WEST SUSSEX COUNTY COUNCIL CONSULTATION

TO:	Arun District Council FAO: Mr Z Denton
FROM:	WSCC - Highways Authority
DATE:	9 December 2020
LOCATION:	40 Little Paddocks Ferring BN12 5NJ
SUBJECT:	FG/160/20/DOC Approval of details reserved by condition imposed under ref FG/152/19/PL relating to Condition Nos 5 - materials & finishes, 7 - charging for electric vehicles, 8 - decentralised, renewable & low carbon energy, 11 - acoustic fencing & associated tree & shrub planting and 13 - cycle parking.
DATE OF SITE VISIT:	n/a
RECOMMENDATION:	Advice
S106 CONTRIBUTION TOTAL:	n/a

RS18.54.DC02C

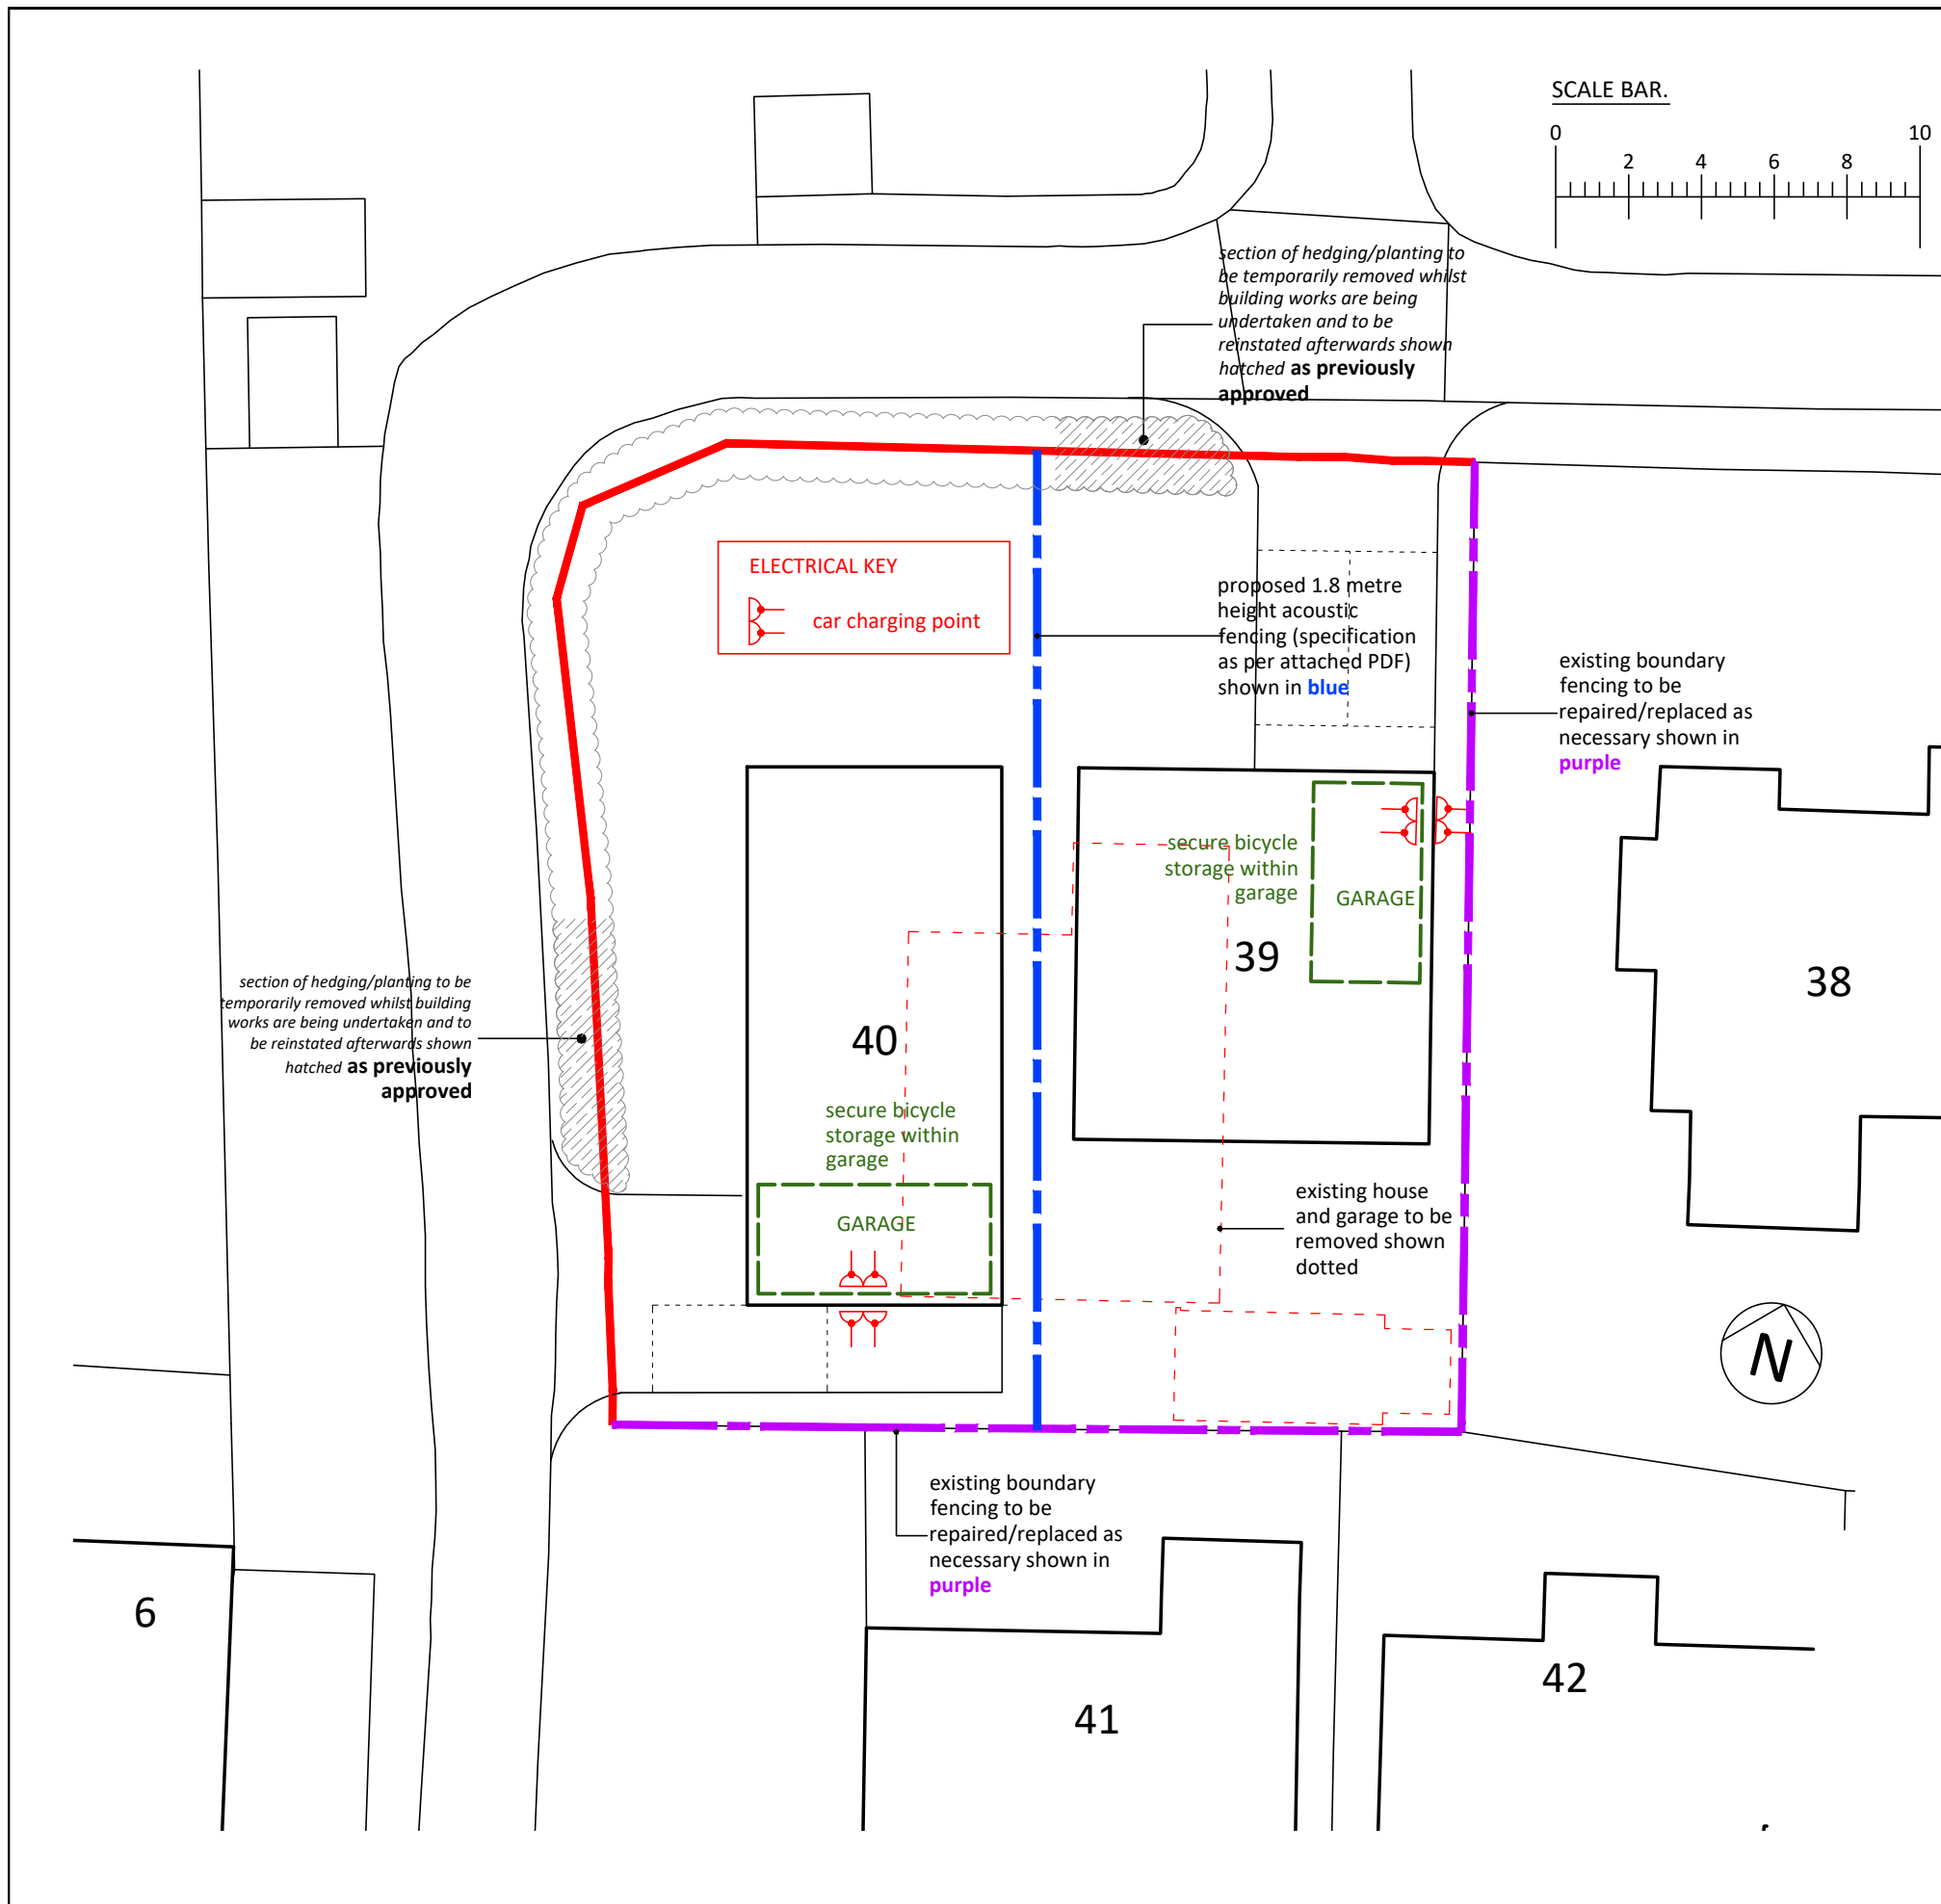
A plan (RS18.54.DC02C - November 2020 Revision C) has been submitted to satisfy the requirements of this condition.

The plans indicate that each dwelling will be provided 4 charging points. This would be considered to be in accordance with the Arun supplementary planning document for parking requirements.

A plan (RS18.54.DC02C - November 2020 Revision C) has been submitted to satisfy the requirements of this condition. Cycle parking will be provided within the garage provisions for each dwelling. While it was established at the planning stage the garage provision for '39' was not considered to meet current size recommendations for vehicles it would be suitably sized to store cycles.

Plans and details submitted in relation to this condition would be considered acceptable.

Plans and details submitted in relation to this condition would be considered acceptable.
